**From:** Jordan Bovee <jordan.bovee.hsy@colvilletribes.com>  
**Sent:** Monday, July 14, 2025 2:51 PM  
**To:** Ellie Myers  
**Cc:** Guy Moura; SEPA@dahp.wa.gov  
**Subject:** Re: SP-25-00009 Brown Road - Notice of Application

**PROJECT: Brown Road (SP-25-00009)**

**RE: SEPA 202502902; SP-25-00009**

**TO:** All Staff  
**FROM:** Public Works Plan Review Team  
**DATE:** July 30, 2025  
**SUBJECT:** SP-25-00009 Brown Road

BROWN ROAD SHORT PLAT
 PART OF SECTION 4, T. 17 N., R. 18 E., W.M.
 KITTITAS COUNTY, WASHINGTON

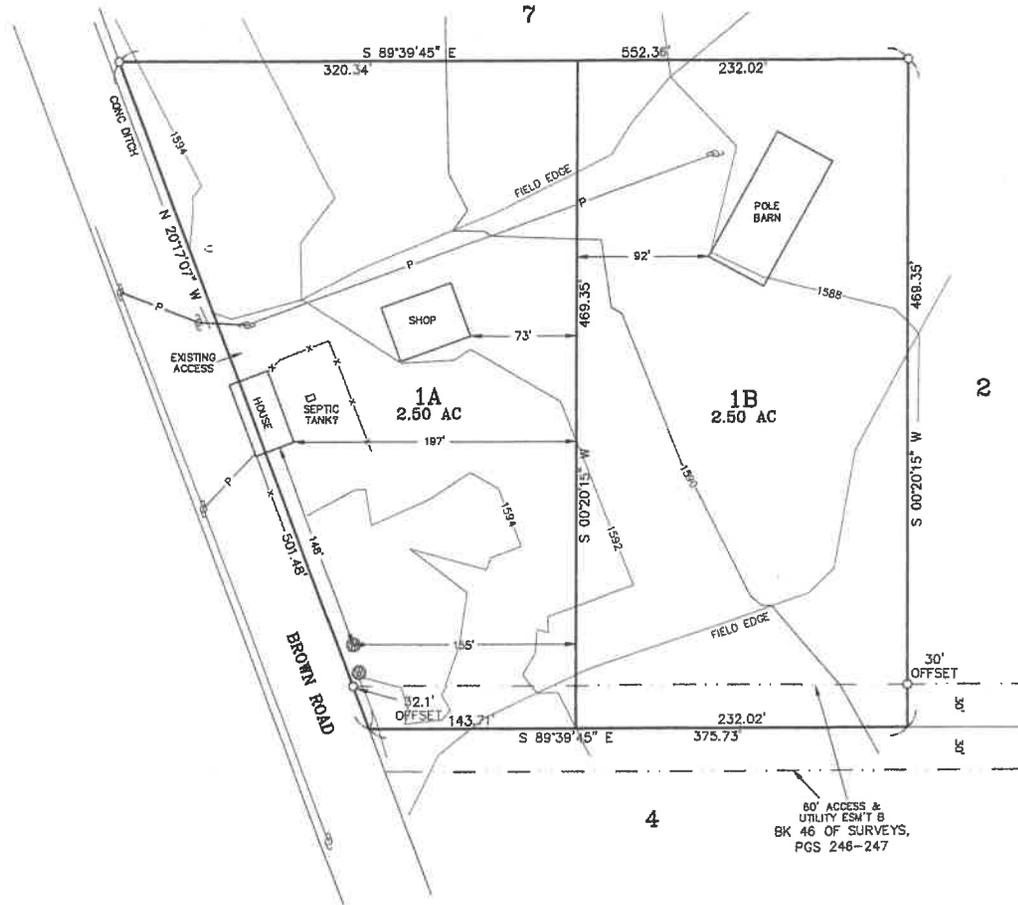
<p><b>SURVEY</b></p>	<p>1. Application does not meet WAC 332-130-145 Topographic elements on map.                  2. show encroachment distances of existing building(s) into Brown Road Right of way.                  3. 2024 Aerial photography shows 5 additional buildings not shown on the application. These should be shown or a statement from the applicant stating that they have been removed.</p> <p>FOR FINAL (not required for Prelim Approval)</p> <p>4. Include Ownership, surfacing and R/W width for Brown Road.                  5. At a minimum, the new division line between parcels shall be staked in the field, and corners shown on the face of the map.                  6. Adjacent lots 2, 4 and 7 shall include reference to recorded survey.                  7. The 60' access easement shall include reference to recording number of the creation documents, as the survey only notes that is to be created by separate document.                  8. Given the simplistic nature of the SP, Lot Closures are not required at final.                  (JT)</p>
